Application no: 23/01184/DISC

Location: Great Wolf Lodge Oxfordshire, Kirtlington Road, Chesterton, OX26 1TE

Transport Development Control

Condition 14 No objection

Drawing Title
VISITOR CYCLE PARKING

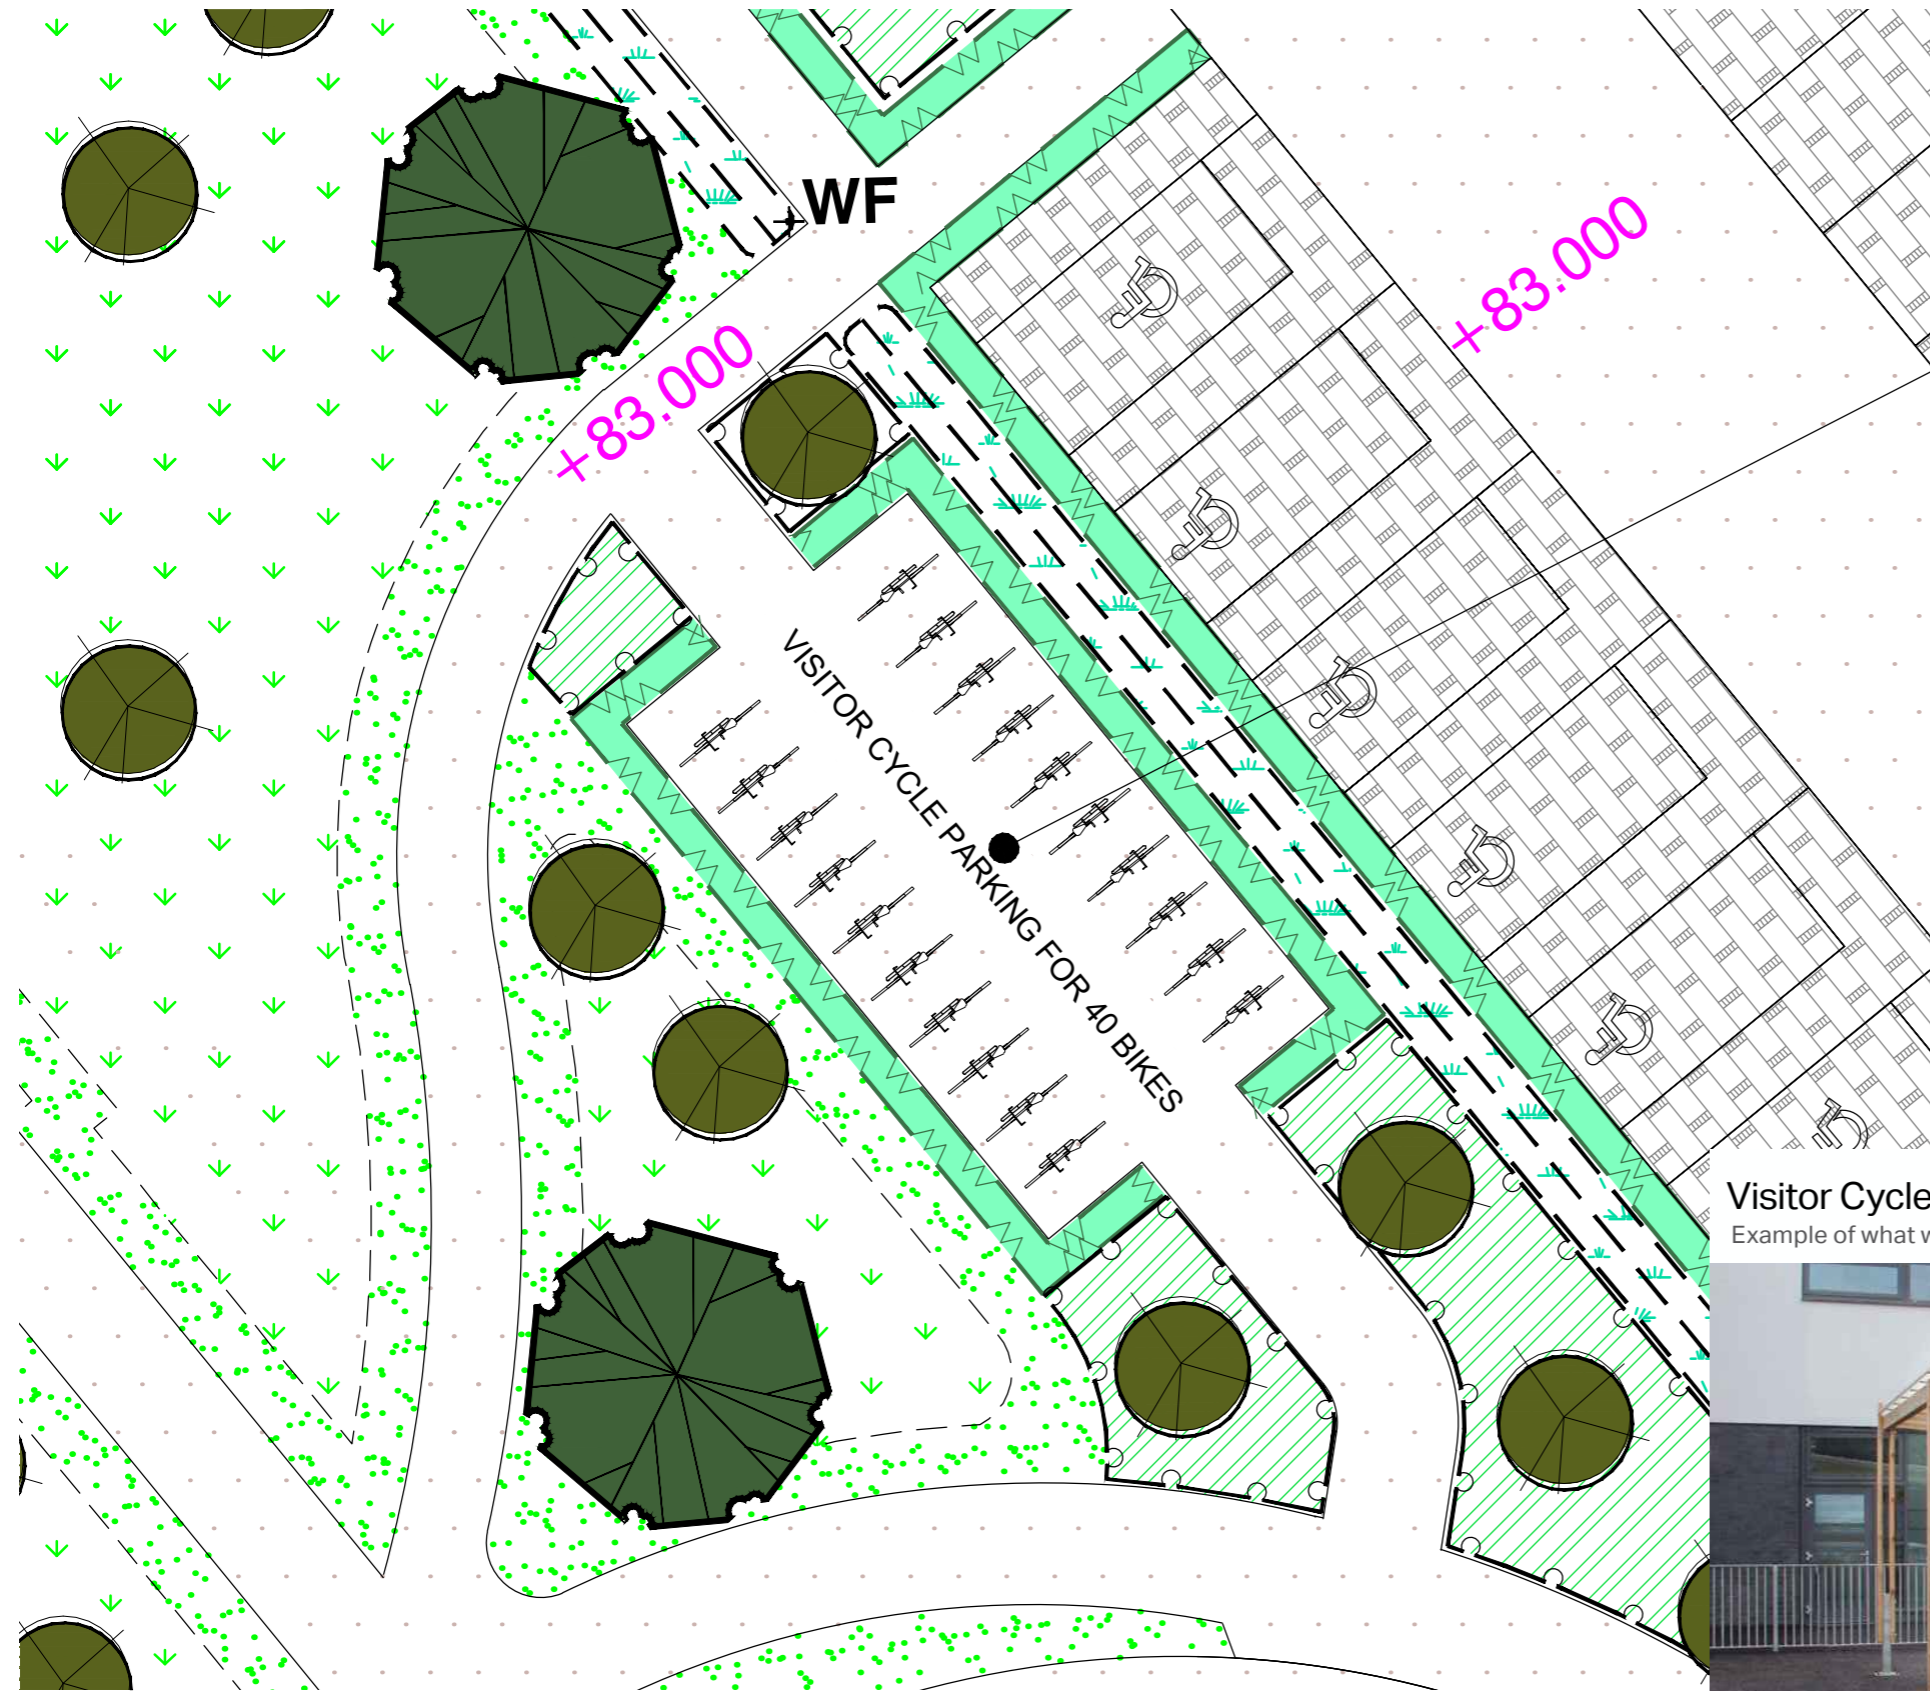
As very few guests will be arriving by cycle, the covered outdoor storage area for 40 cycles is also considered adequate.

Cycle Stands - AM-XX-AA-001

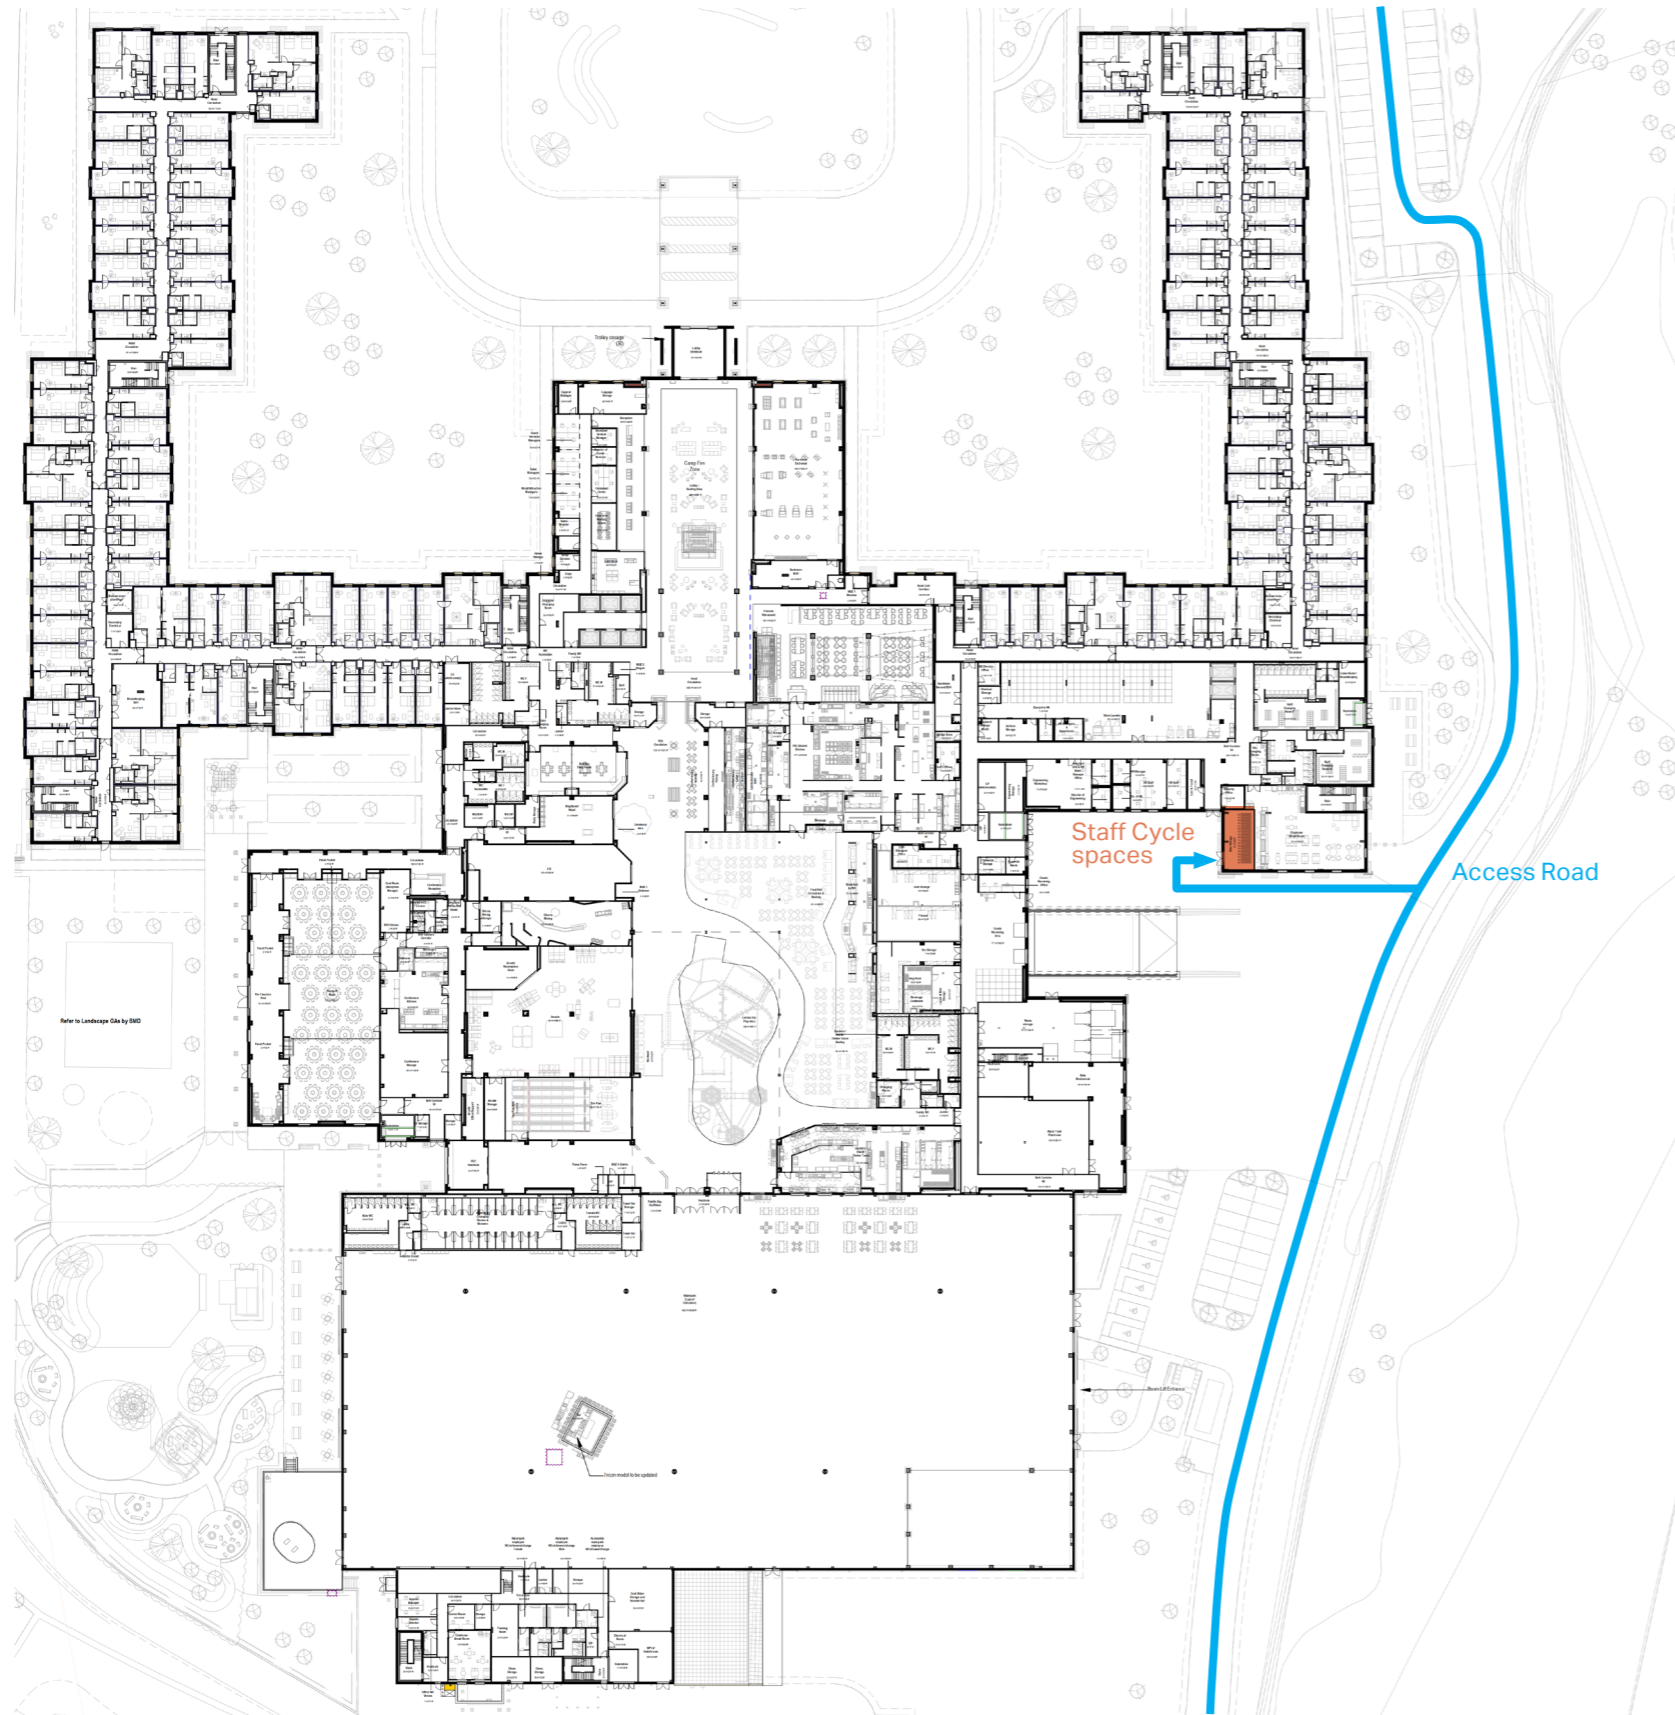
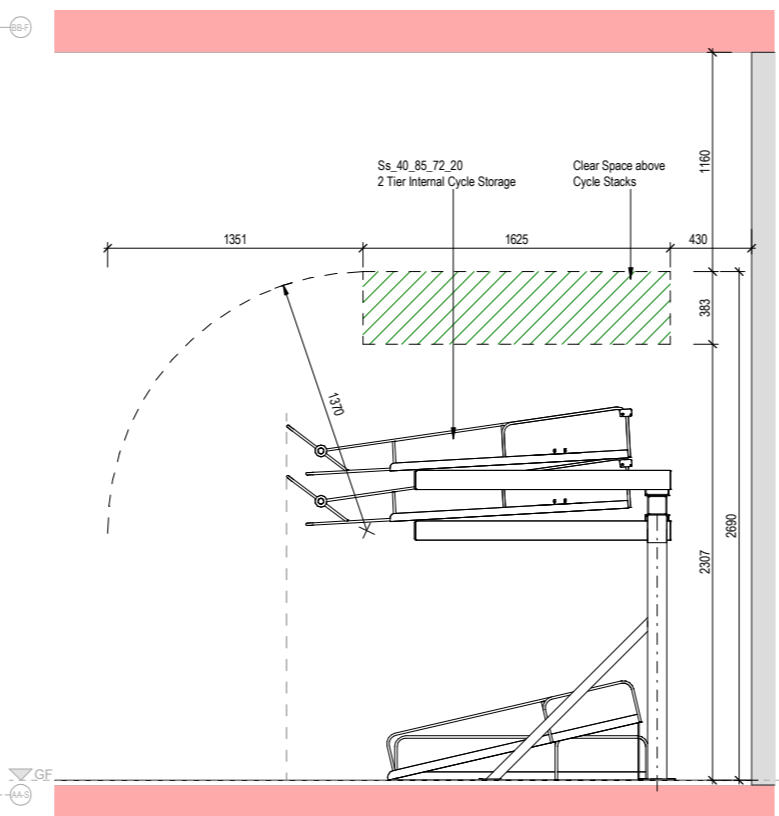
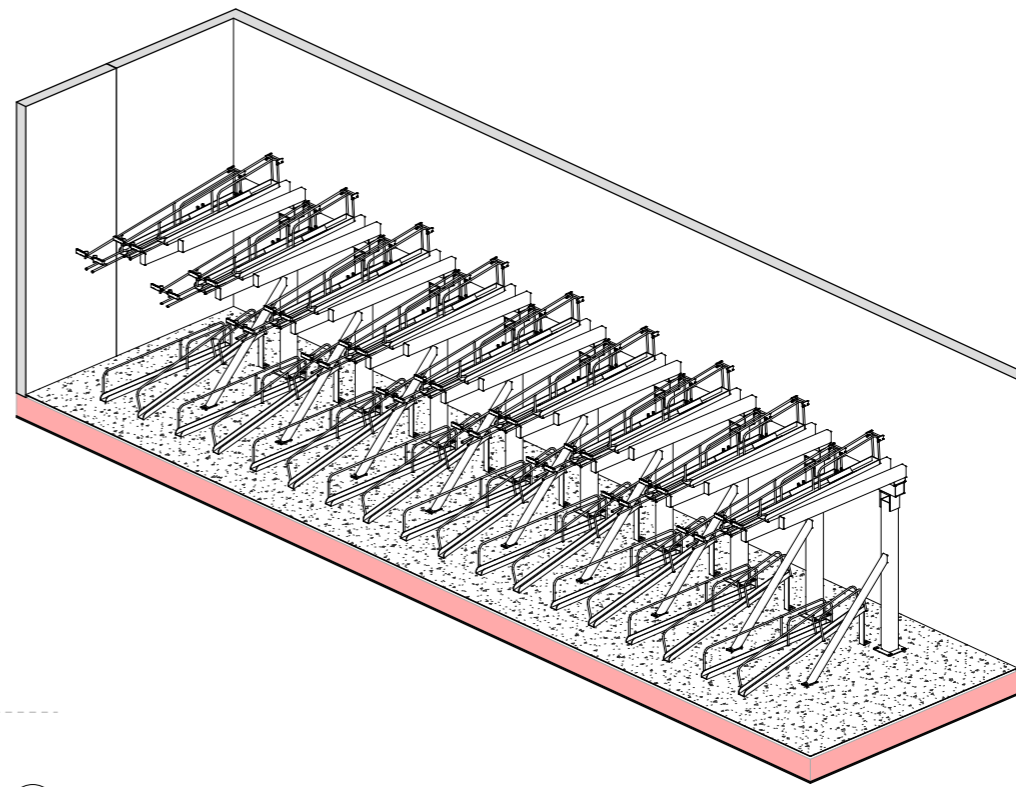
The number of cycle stands is now governed by the OCC Parking Standards for New Developments document. As the most appropriate use class for the whole development is E - Assembly and Leisure, the guideline provision is one space per five employees. Given that approximately 200 staff will be on site at any time, the facility with 36 spaces is considered adequate. The space will be covered and secure.
